SECTION 4.55(1A) MODIFICATION APPLICATION – SSD 6966 BUILDING R5, ONE SYDNEY HARBOUR, BARANGAROO SOUTH

This modification application has been prepared by Ethos Urban on behalf of Lendlease (Millers Point) Pty Ltd (Lendlease), pursuant to section 4.55(1A) of the *Environmental Planning and Assessment Act 1979* (EP&A Act) to modify Development Consent SSD 6966 relating to Residential Building R5 at Barangaroo South (the site).

## R5 ELEVATION SOUTH -WEST (WATERMANS QUAY)

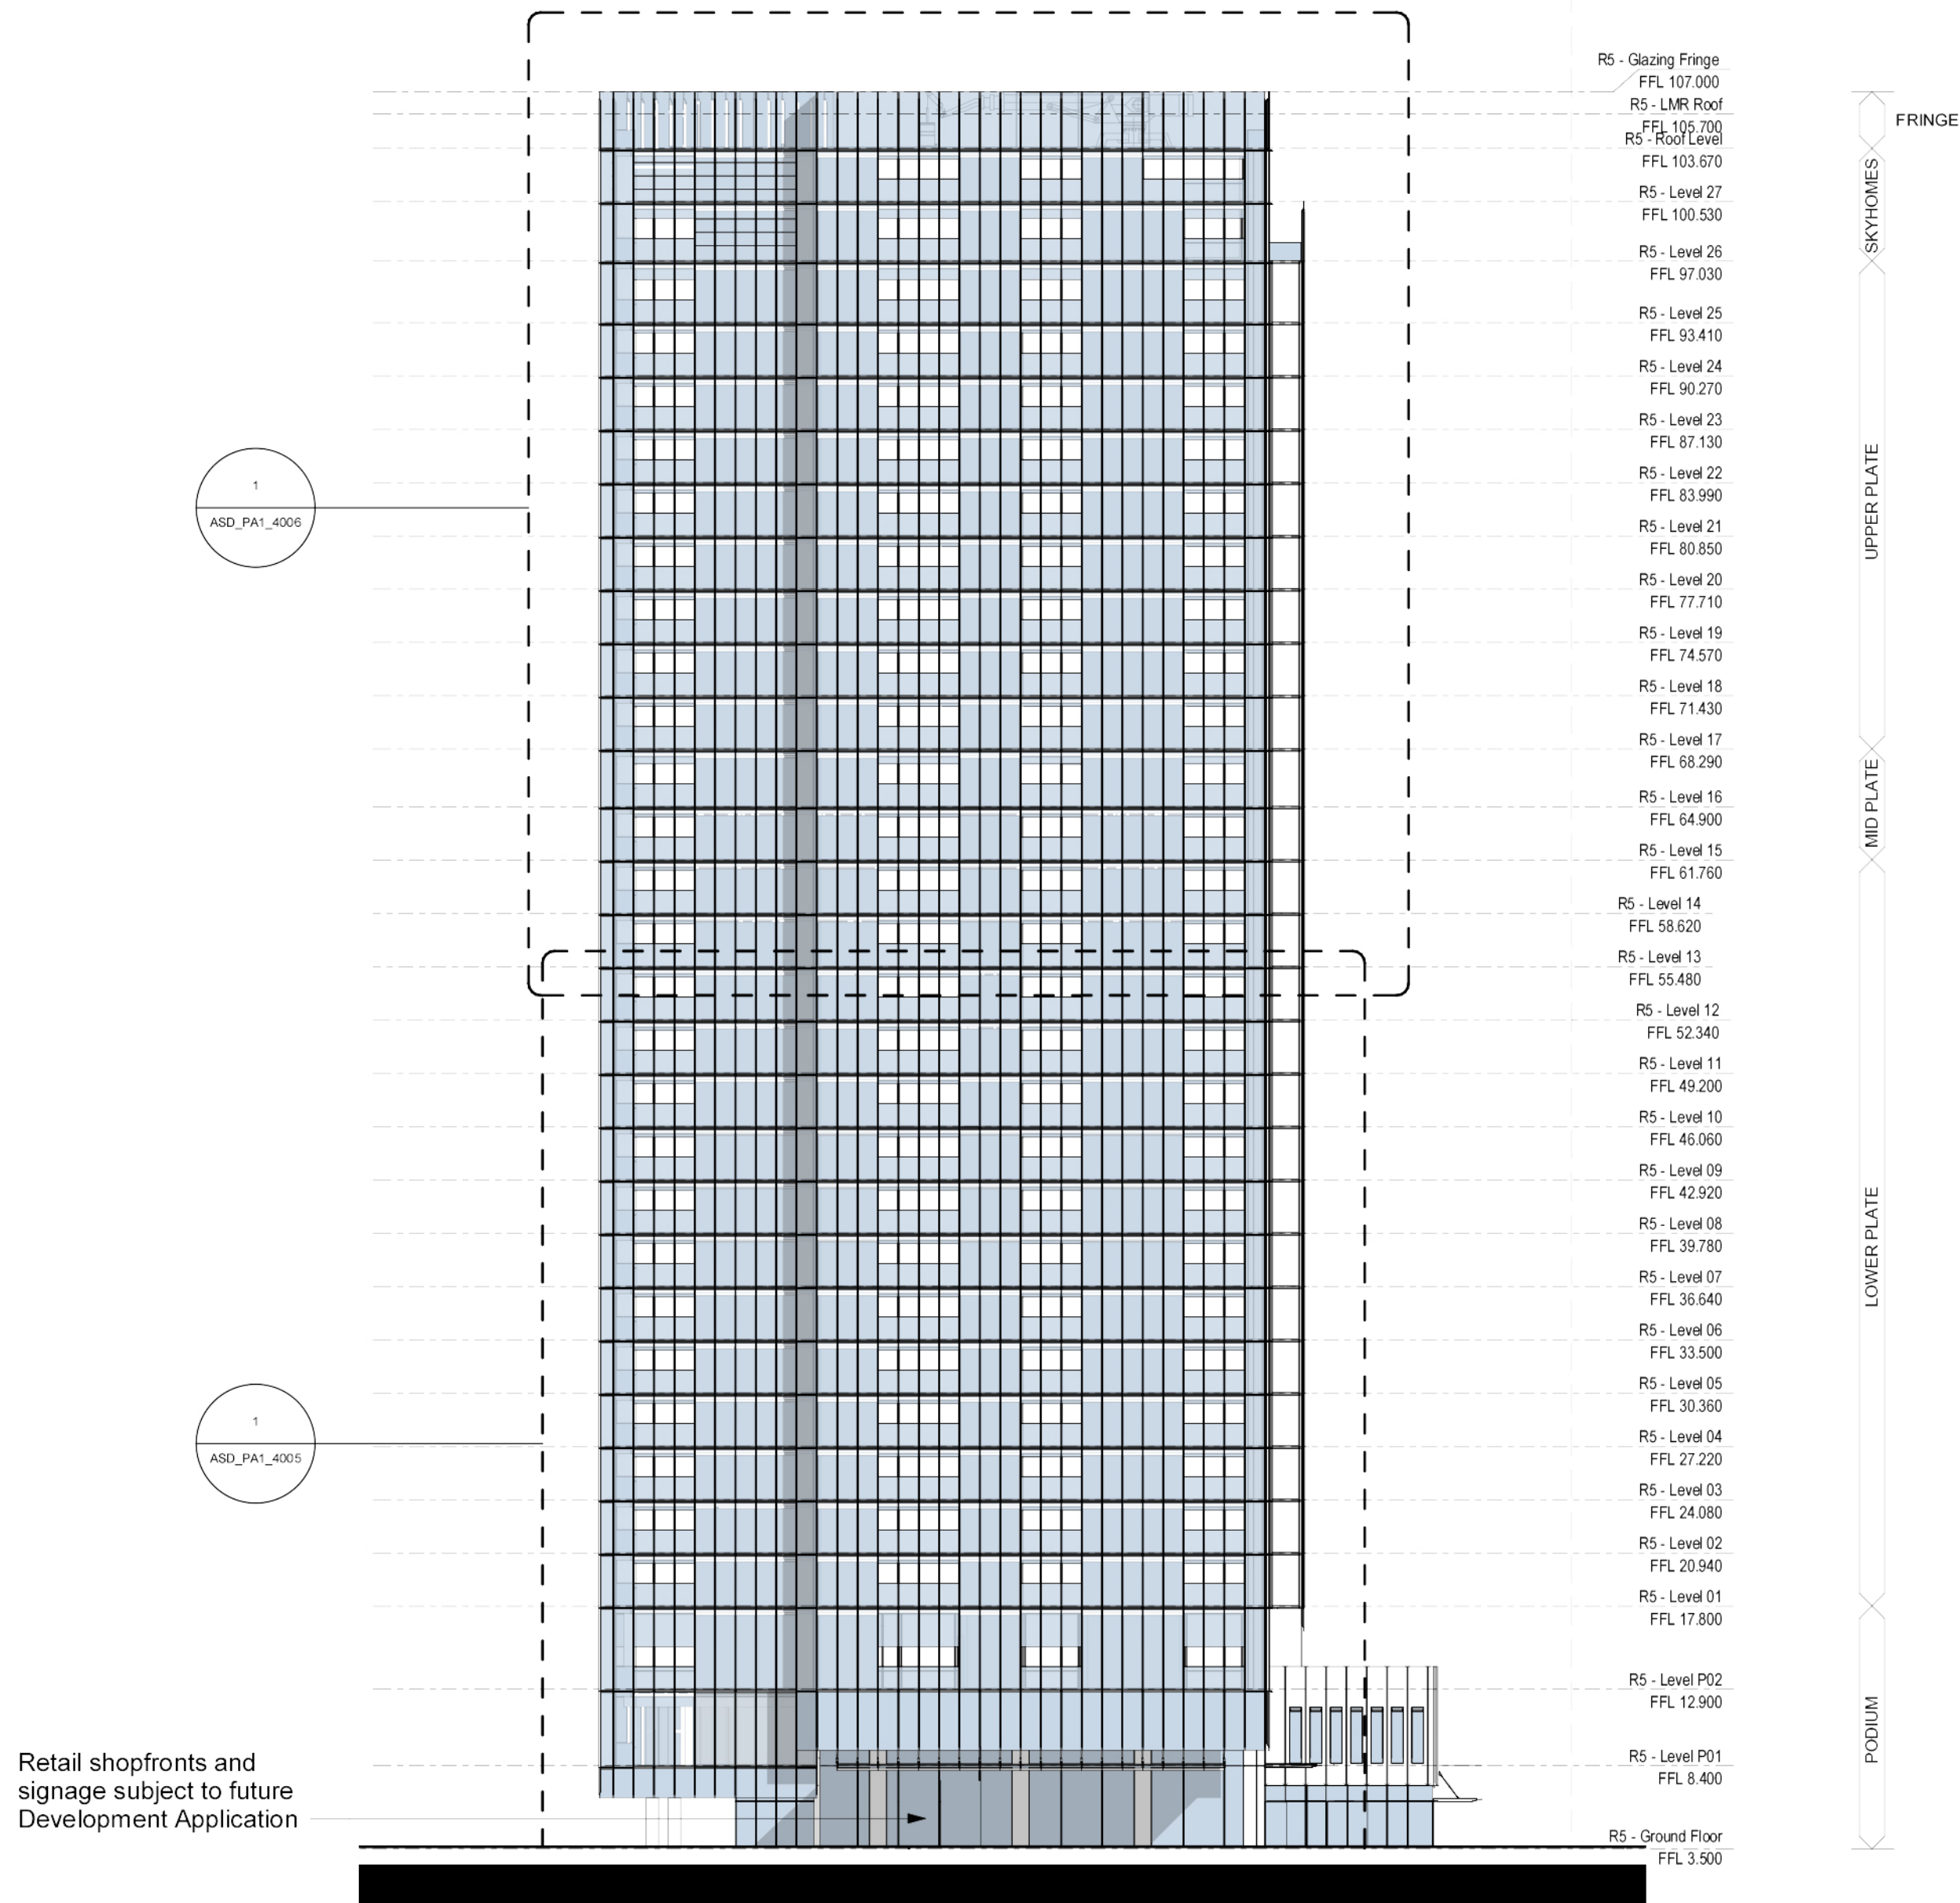
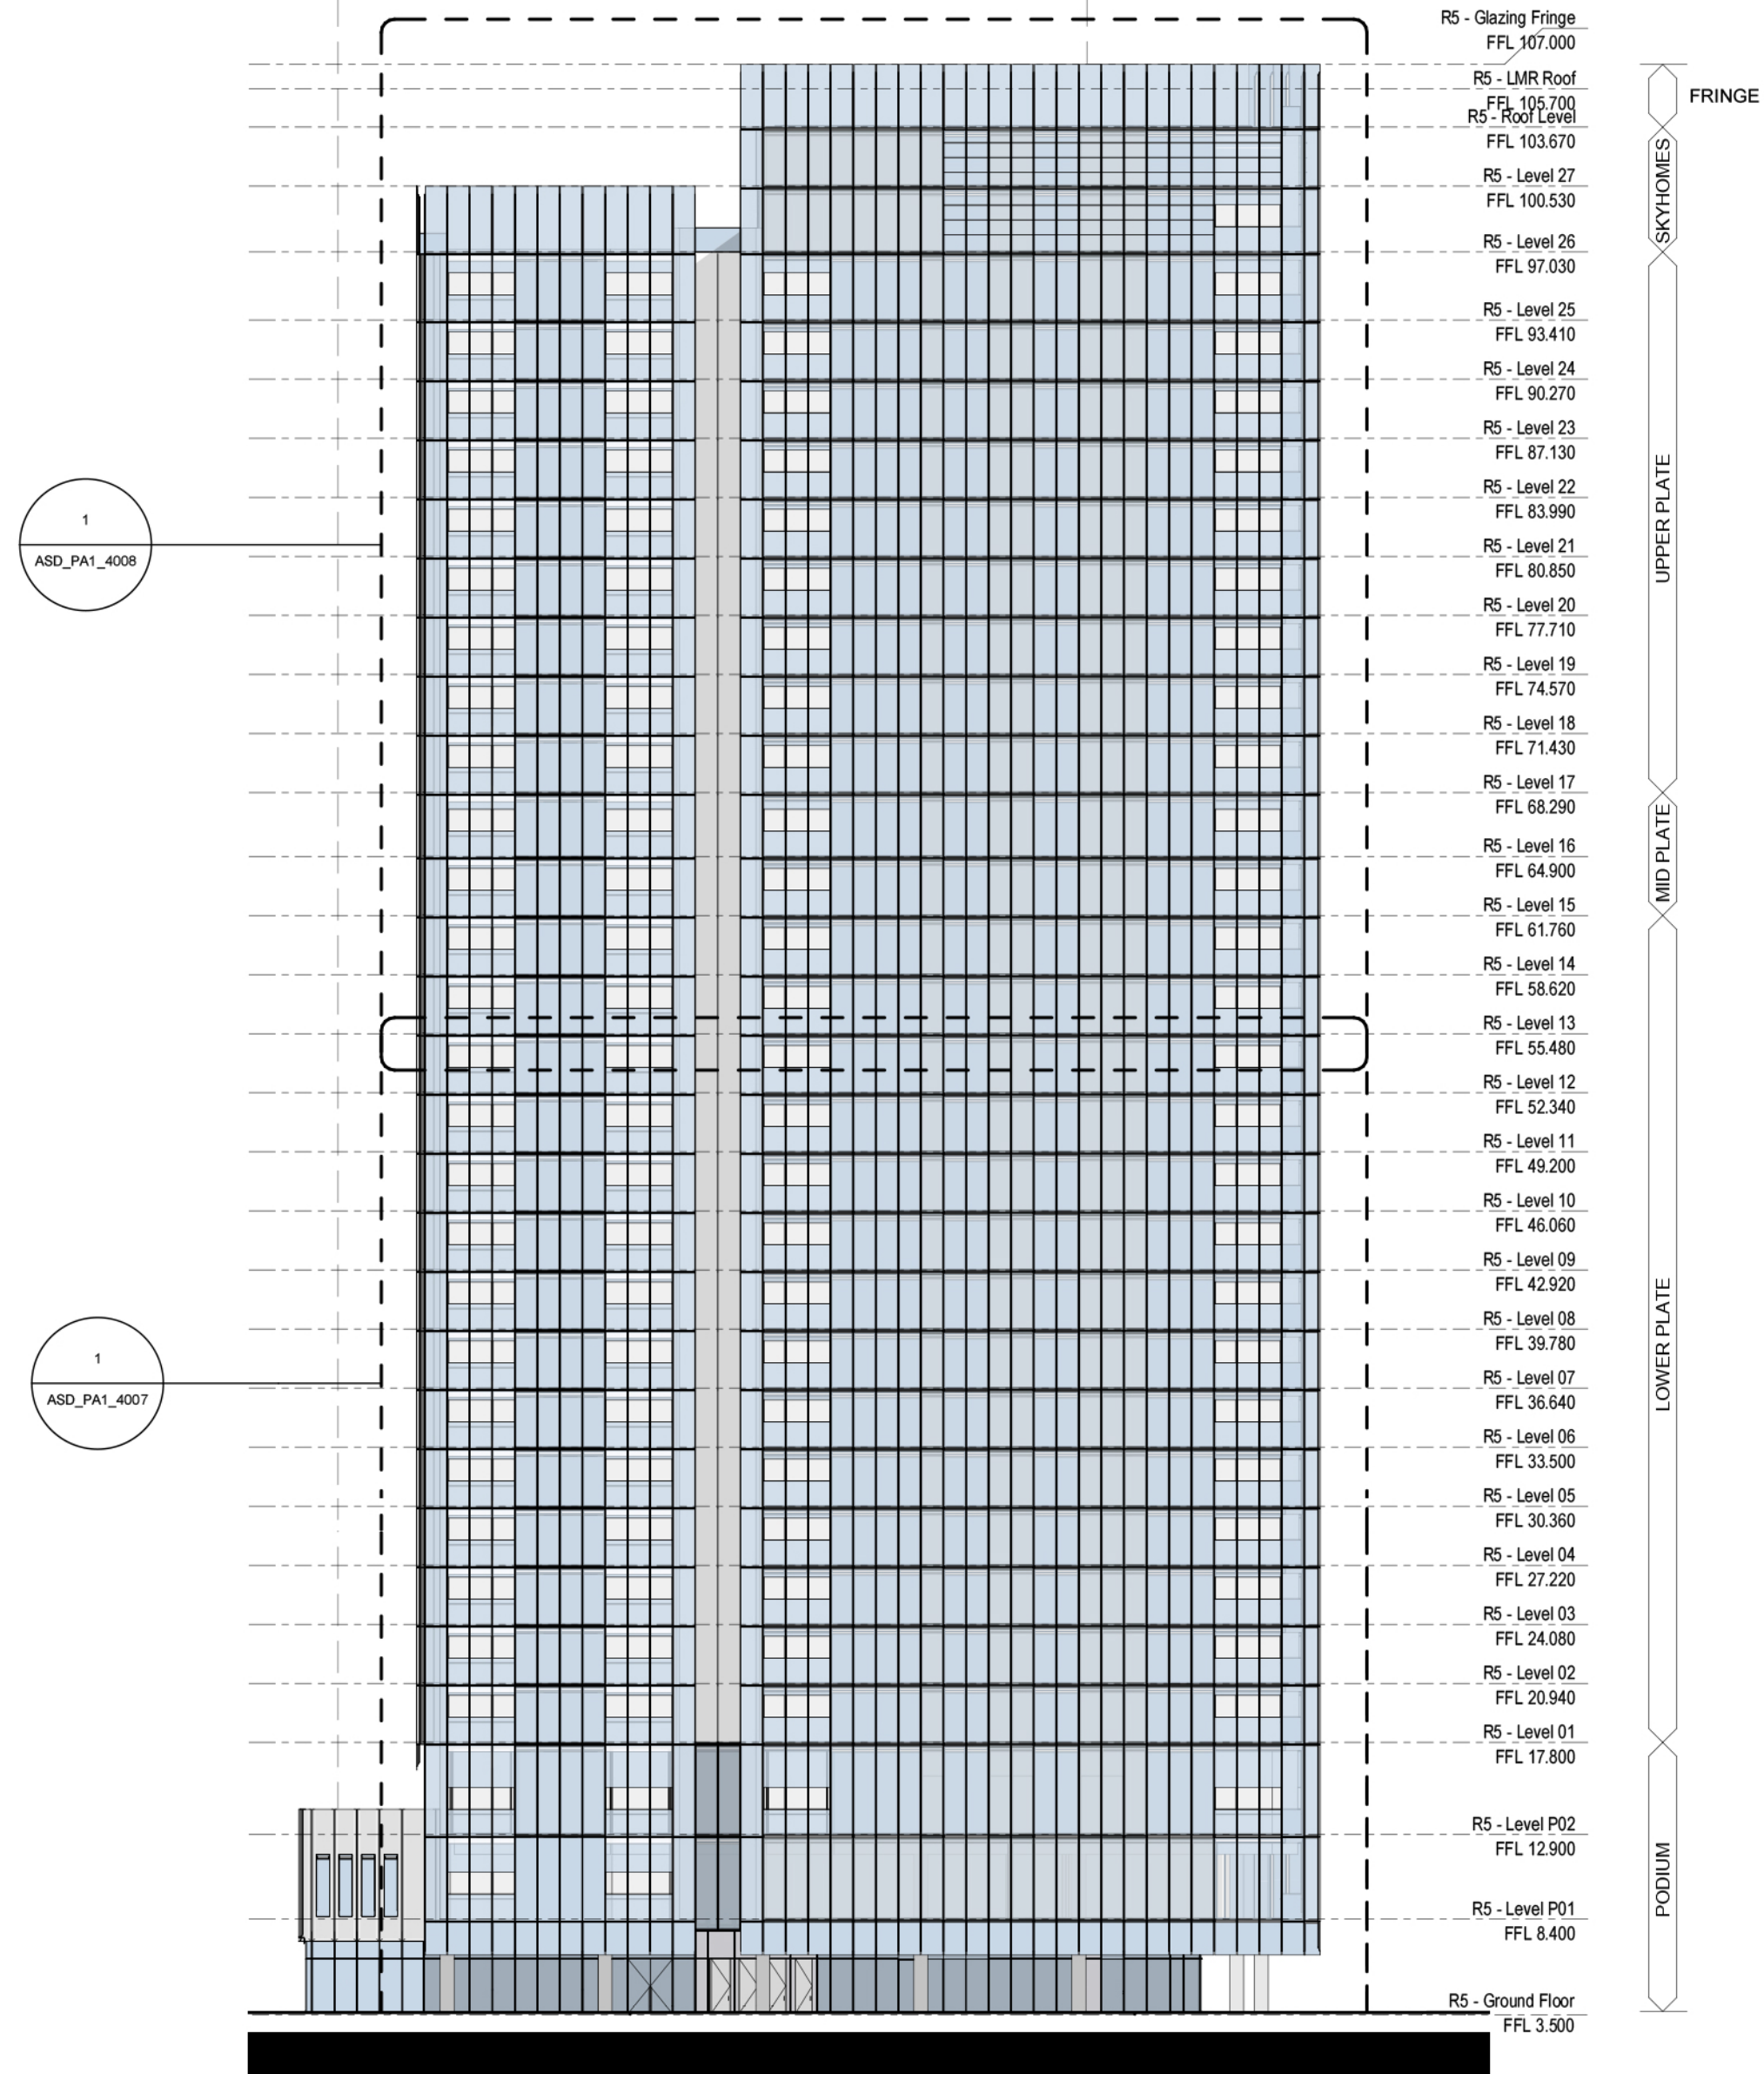
The proposed modifications include the installation of retail shopfronts. Under the current consent and within the existing stamped plans, the approval of these shopfronts is subject to a future, separate individual design process and their own Development Application (DA). On a further design review, it is considered that providing for the shopfronts as part of an integrated approach will provide a better response to the broader architecture of the building and will result in a more cohesive design outcome together with the other shopfronts approved under Building R4A (SSD 6964) and SSD 6965 (as amended by SSD8892218).

It is proposed to reconfigure the façade at the ground level elevation to facilitate the following:

- Additional retail shopfronts/entrances around the ground floor of the building.
- Additional door for fire booster cabinet fronting Hickson Road.

Southwest Elevation

Approved

Proposed

Figure 3 Façade changes on the southwestern elevation
